Please ask for: Sian Eggington  
Email: [sian.eggington@terraquest.co.uk](mailto:sian.eggington@terraquest.co.uk)  
Telephone: 0121 2341390  
Our Ref: FP/167/21/HH  
Your Ref:  
Date: 22nd July 2021

**Application for Planning Permission for Works or Extension to a Dwelling**

**Development:** Two storey side extension  
**Location:** 126 Flansham Lane Felpham PO22 6BB

Block Plan
Scale 1:200 @ A3

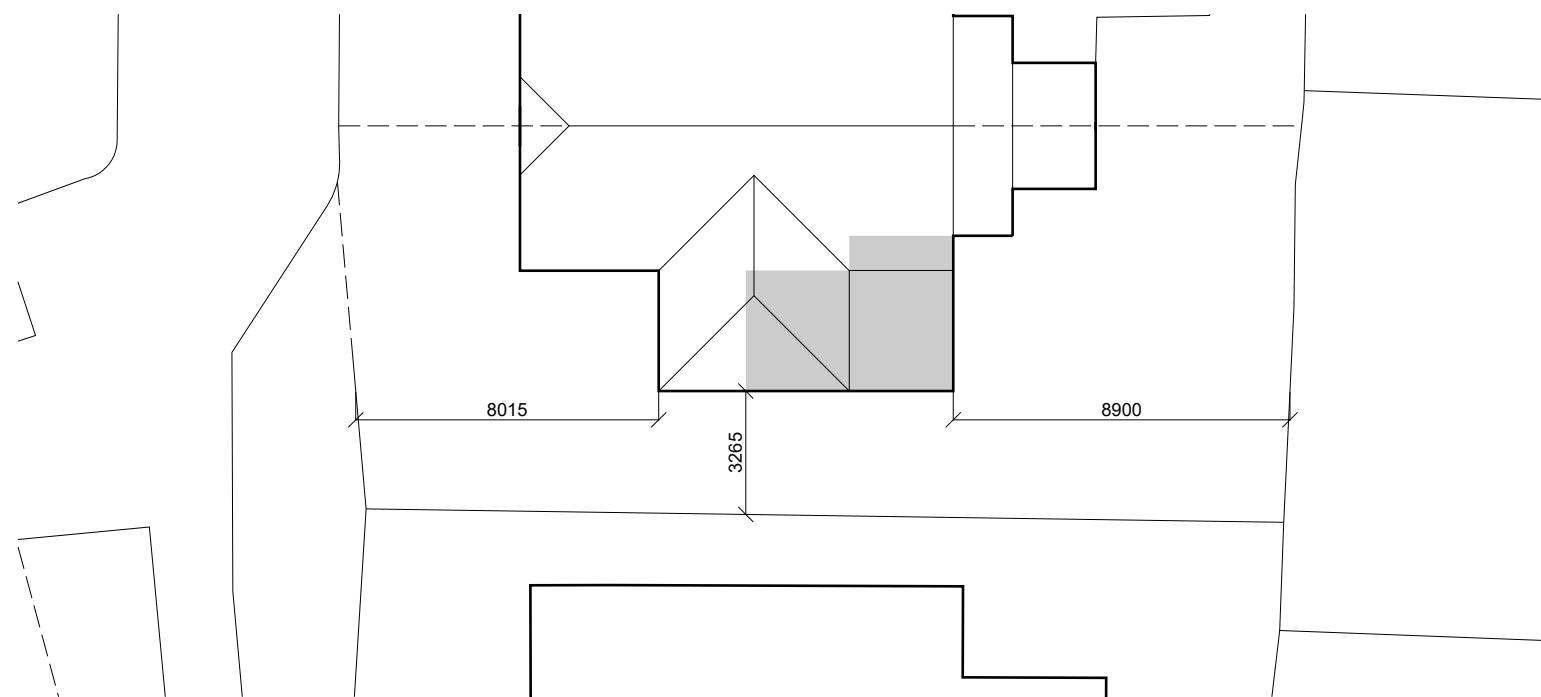
**Block Plan**

You are required to have dimensions from the proposed extension(s) to all site boundaries. Please amend.
